City of Albuquerque

RE: SCOT SHAPIRO APARTMENTS, 223 Cornell Dr SE (K16-D62). GRADING AND DRAINAGE PLAN FOR BUILDING PERMIT APPROVAL. ENGINEER'S STAMP DATED APRIL 5, 2001.

GRADING AND DRAINAGE PLAN 1"=10'

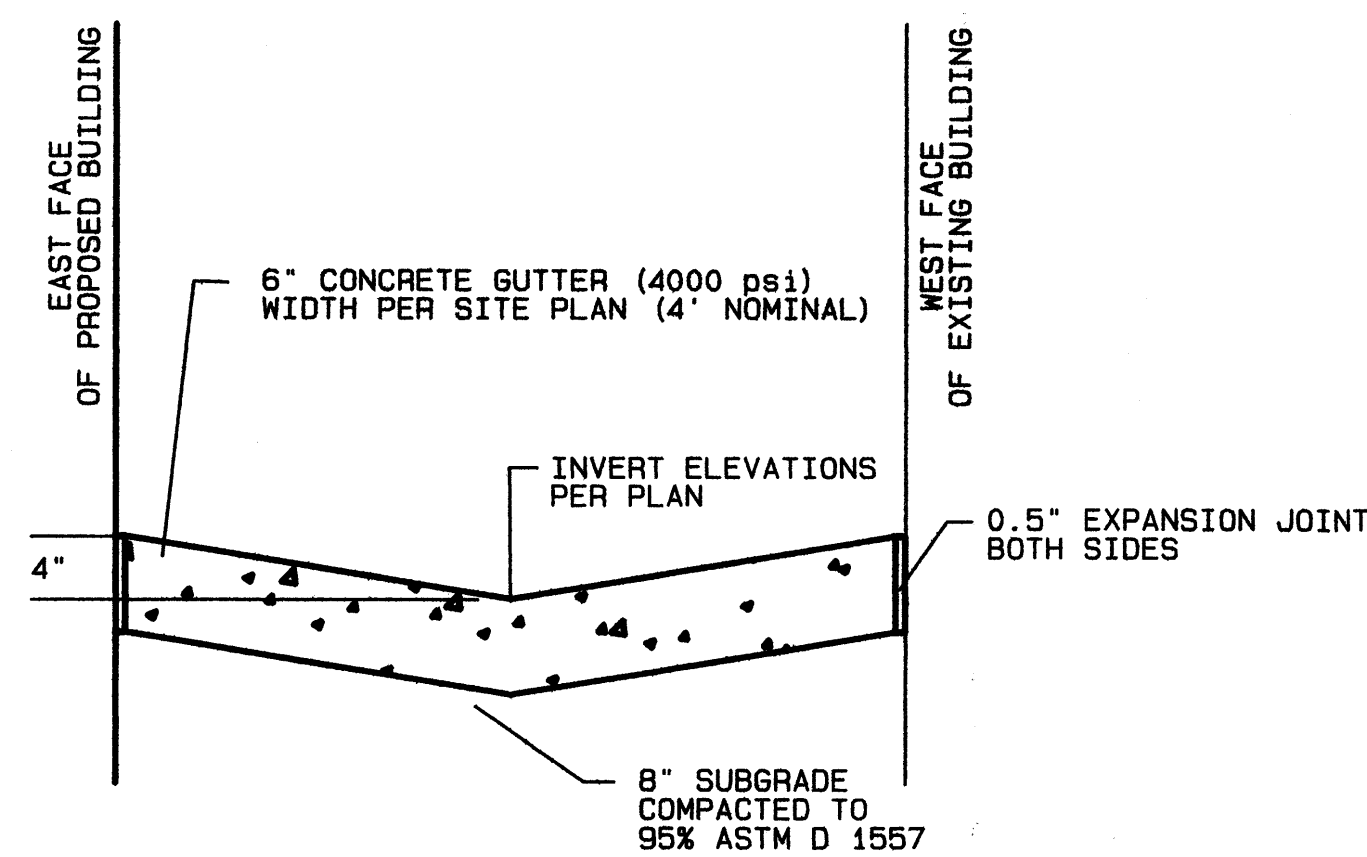
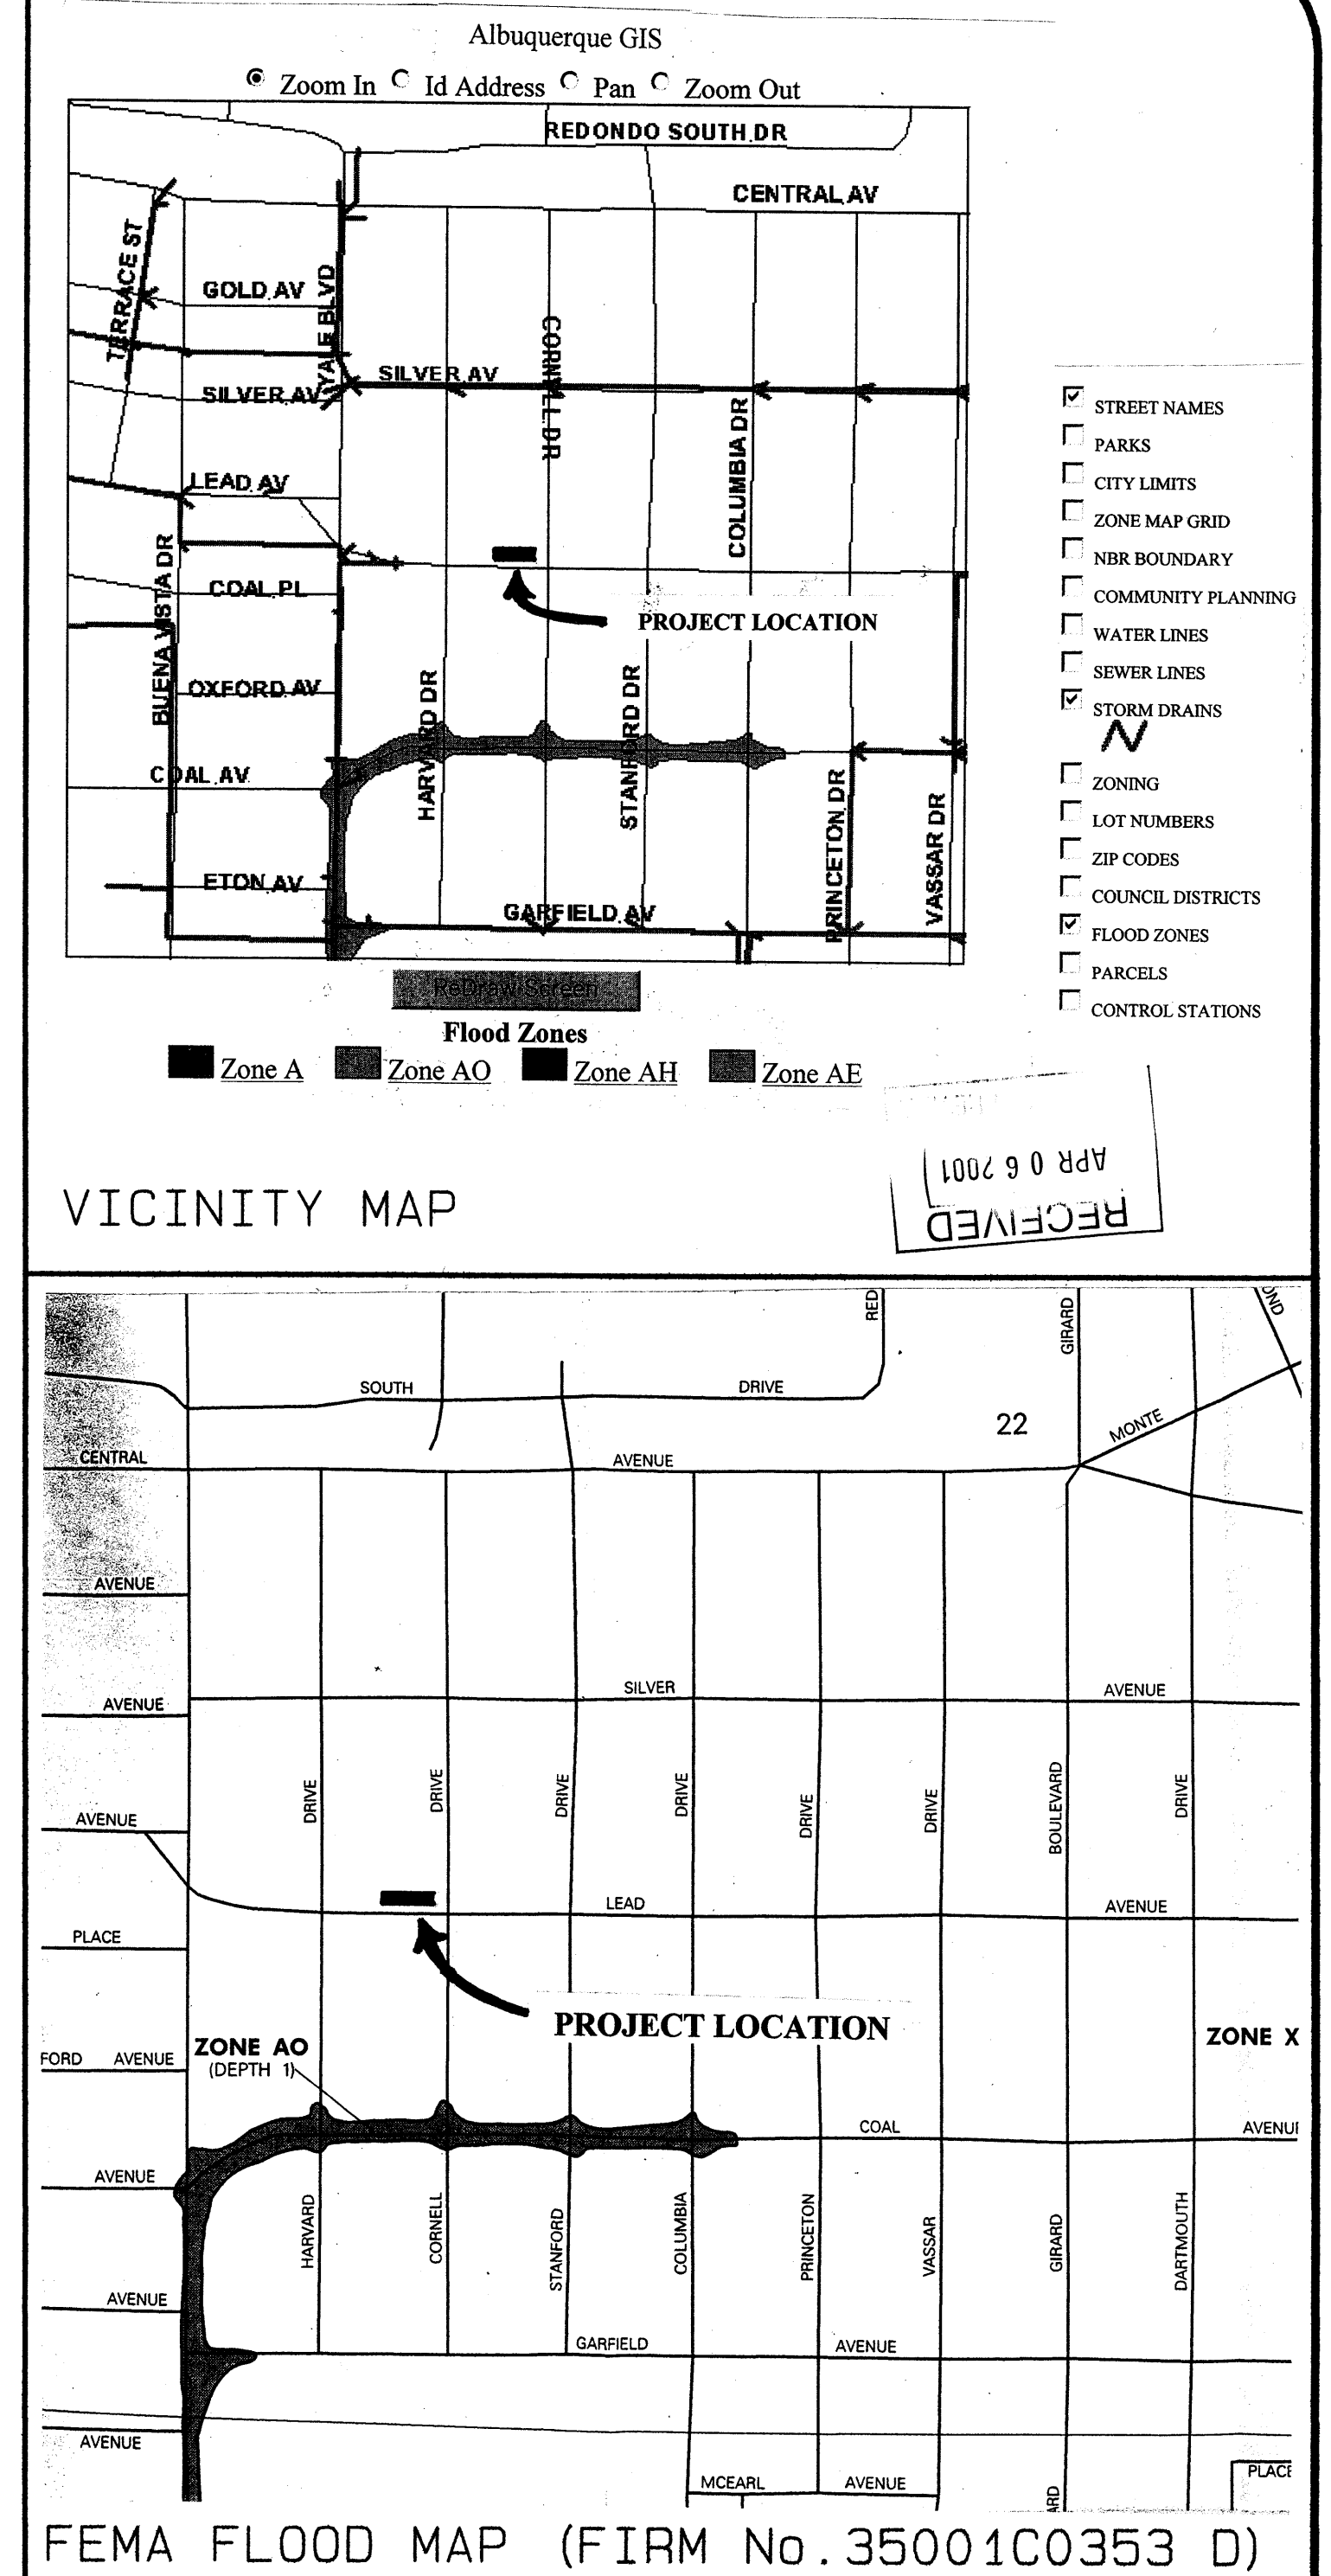
***On Sheet 1, note that the Existing Garage is to be removed (as stated on Sheet 2) especially since you show a swale going through it.
